**Consultation Response from KC,
Highways Development Management**

2024/90817 388, Bradley Road, Bradley, Huddersfield, HD2 1PU

Change of use of existing garden building to create mixed use hair salon to facilitate working from home and residential annex with formation of guest parking spaces

Date Responded: 28/05/2024.

Proposed Site Plan 1.500

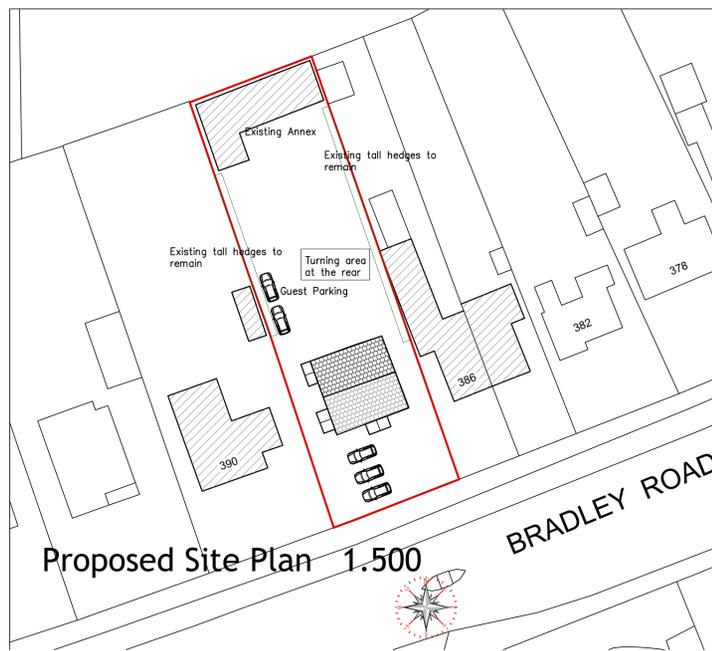
No bin storage areas are shown. A bin collection/presentation point should be located adjacent to the public highway. The bin collection/presentation point must not obstruct the adopted highway or the access road.

Details of waste storage and collection should be provided, with the location of a waste collection presentation point being clearly marked on a drawing in such a location that is easily accessible to the collection team and where it will not obstruct the parking, access or the adopted highway for road safety reasons.
